The City of Fountain has generally limited our focus on the proposed main channel improvements located just upstream of the Venetucci bridge. Since the report and design is at a 60% phase, the plans and report are not complete enough to provide a technical review, so our comments are more geared towards information that is missing, rather than technical review. Due to the concerns stated herein, we would like to be able to review the next phase of design if that is planned. (e.g. – 90%).

MAIN - PROFILE VIEW
STA. 12+73 TO 11+10

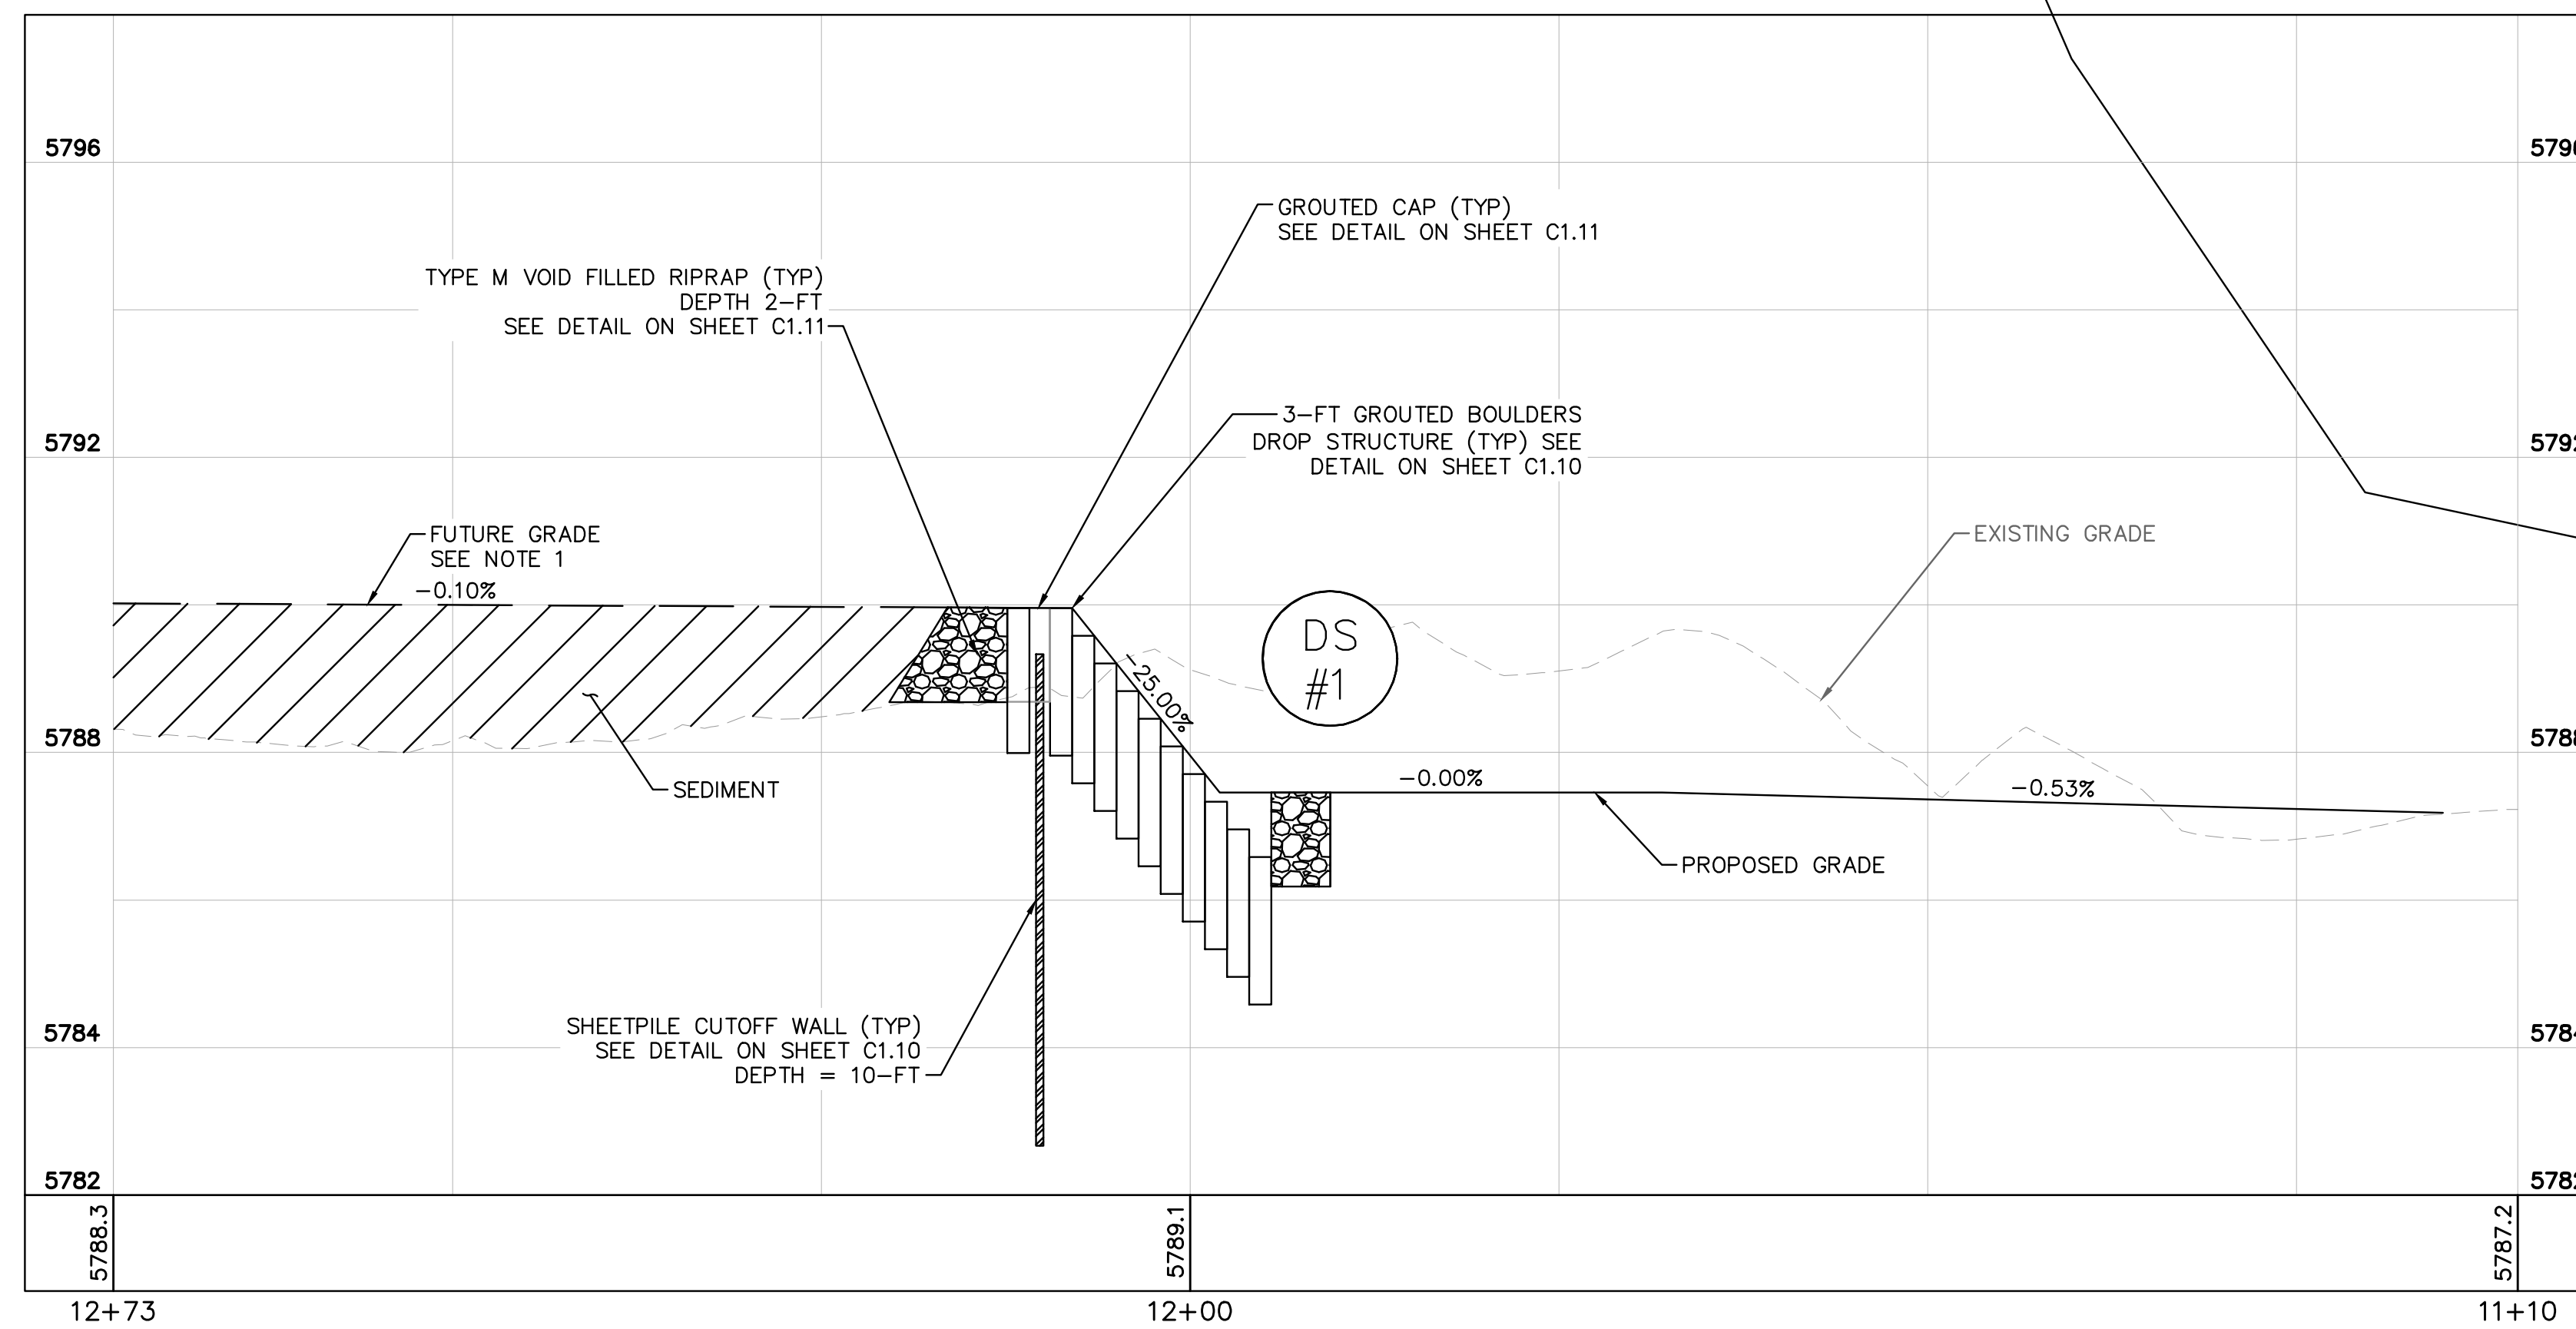
6. The existing bed profile shown on the plans for the proposed drop structure is only slightly above the bottom of the proposed boulders a short distance downstream of the proposed structure. Additional cutoff measures or documentation that that the channel bed is not subject to future erosion needs to be provided with the design.

MAIN CHANNEL DROP STRUCTURE 3 - PLAN VIEW

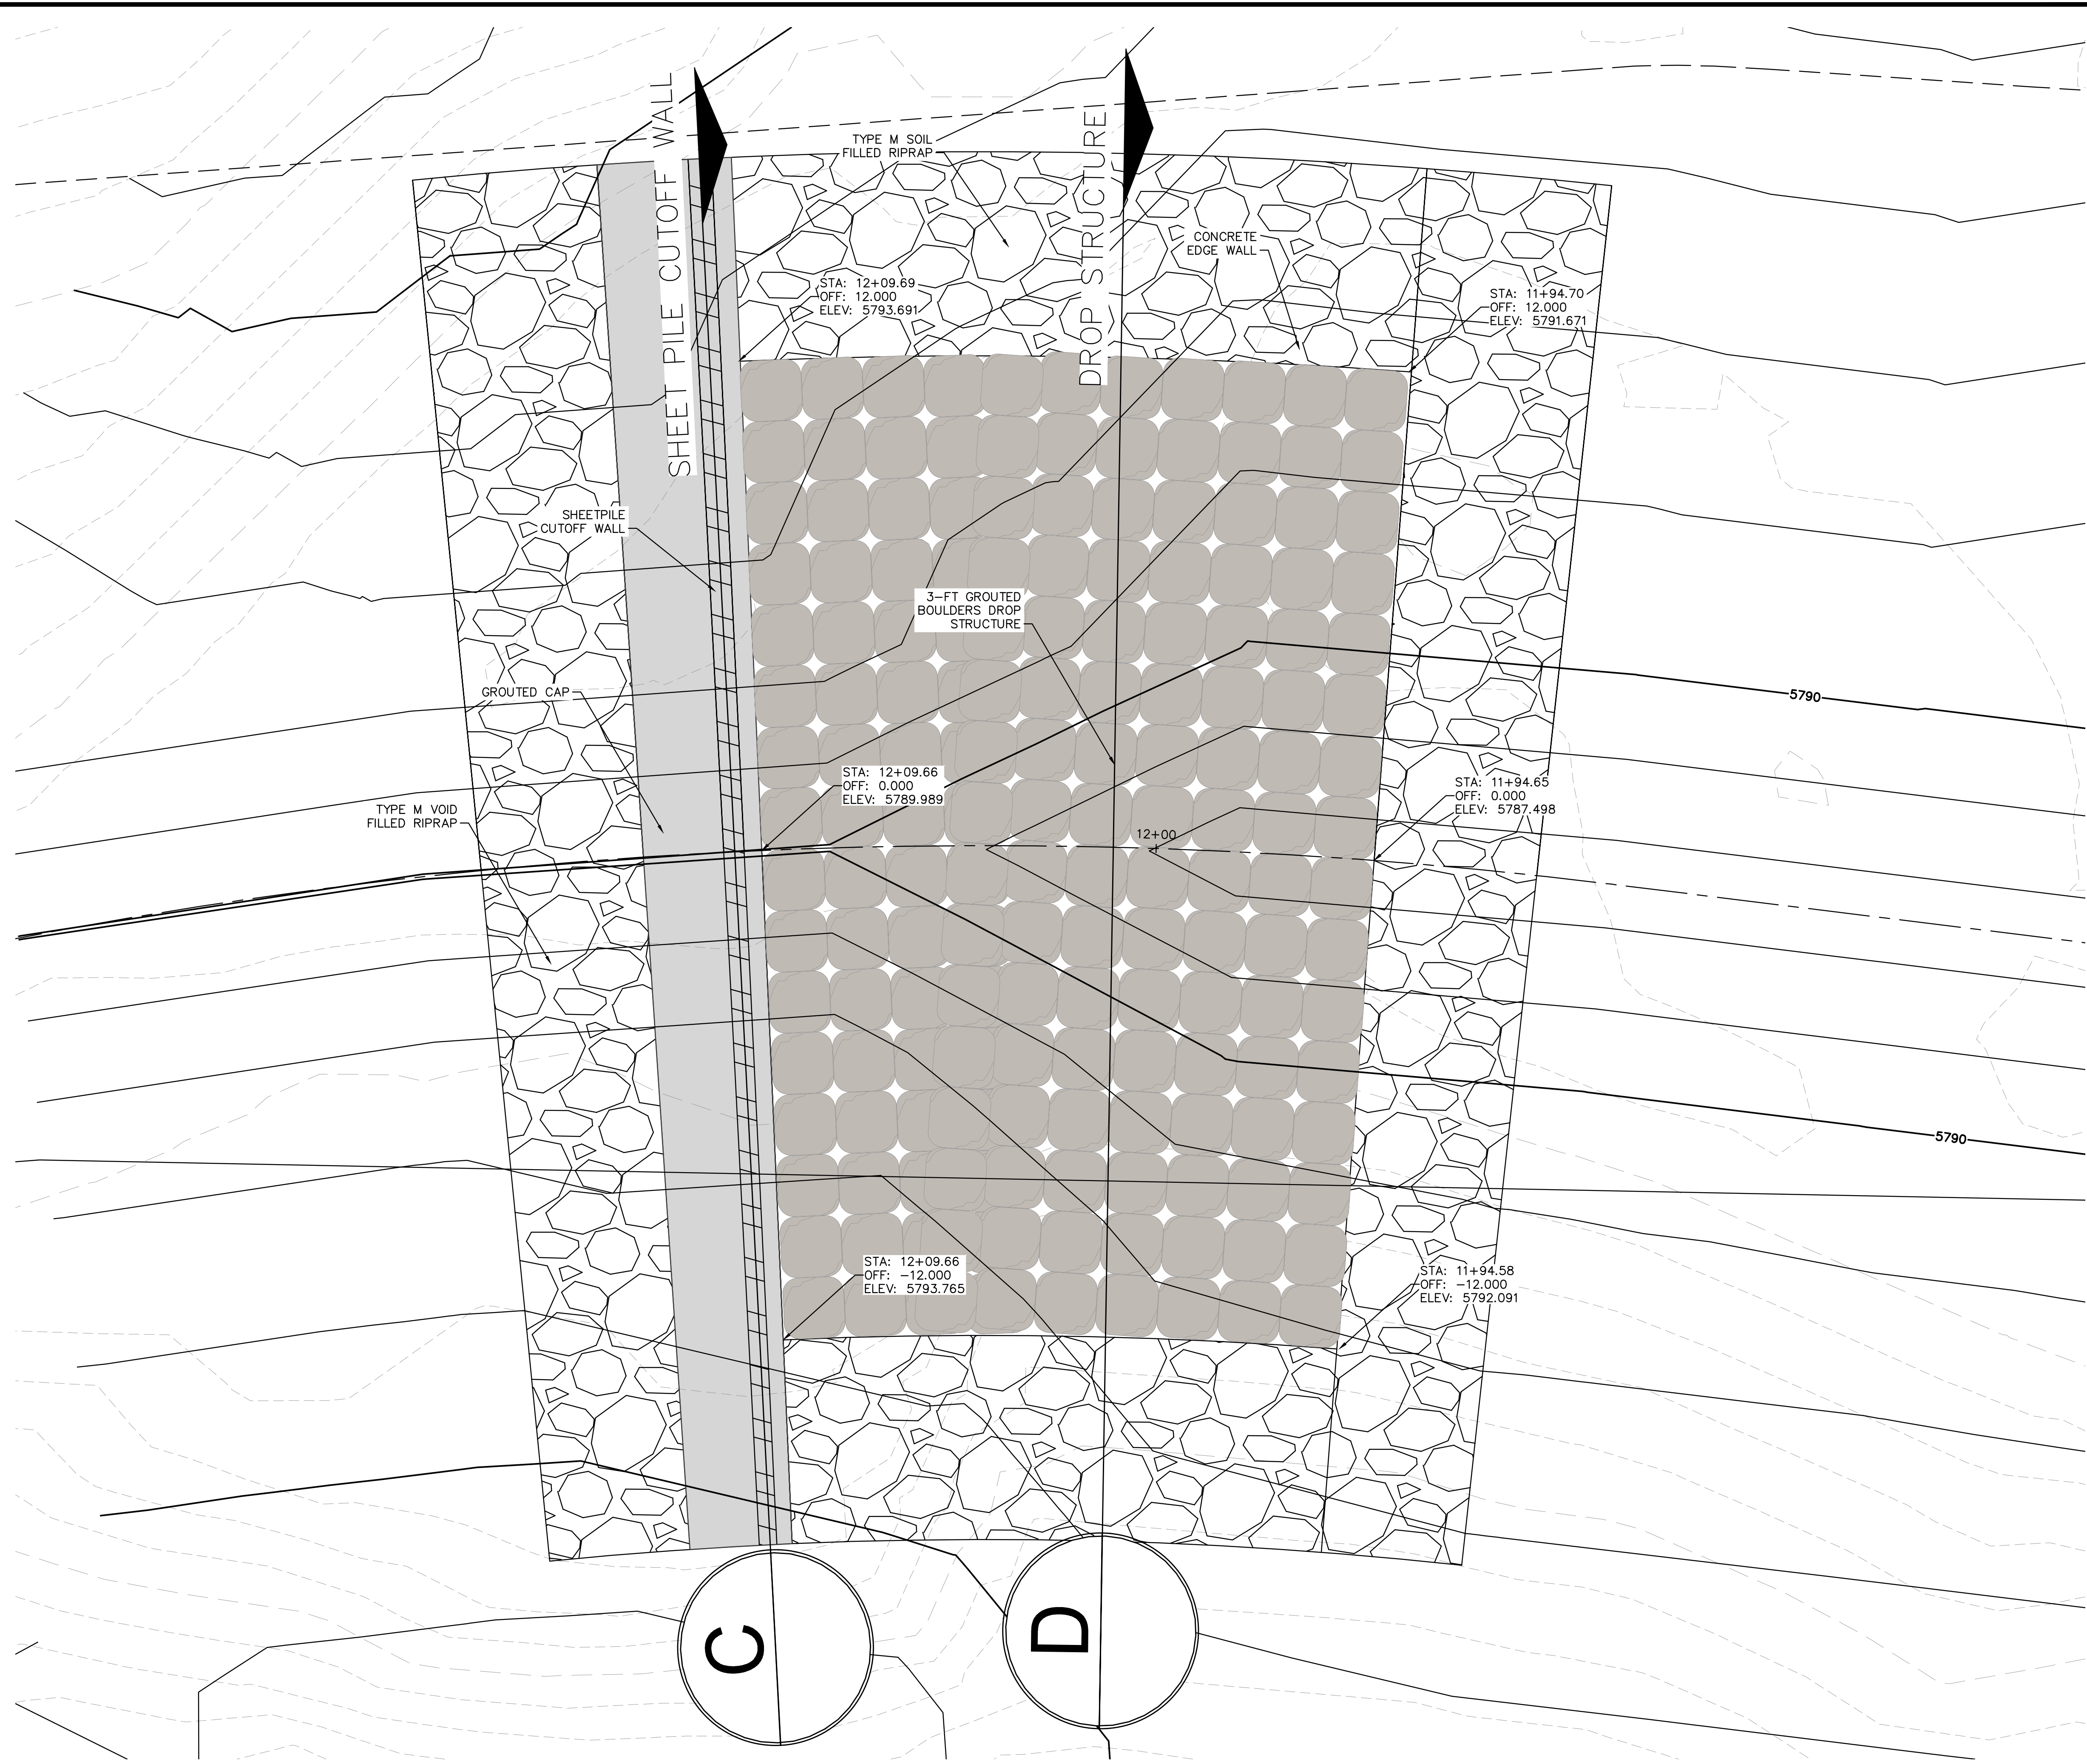
3. The proposed drop structure above Venetucci appears to have been sited based only on the approximate location shown in the 33-year-old DBPS. The Venetucci Bridge has been added since the DBPS was prepared and it is likely that the channel has degraded or otherwise been modified since the DBPS was prepared. We recommend that an evaluation of the existing channel from the upstream side of I-25 to the confluence of the tributary channel be done to determine if the proposed drop structure vertical and horizontal locations are still appropriate.

4. The proposed drop structure design should consider future channel improvements through the existing Venetucci bridge. The bridge, associated topographic mapping, and conceptual future channel improvements through the bridge should be provided in the plans to demonstrate drop structure compatibility with future channel improvements.

5. The proposed drop structure grading does not provide a smooth transition with reasonable side slopes to the existing channel grading at the downstream end. Please provide that in future design submittals.

7. Calculations that demonstrate the adequacy of the proposed drop structure and its proposed materials need to be provided with the design.
8. The datum of all topographic information utilized in the analysis should be provided.
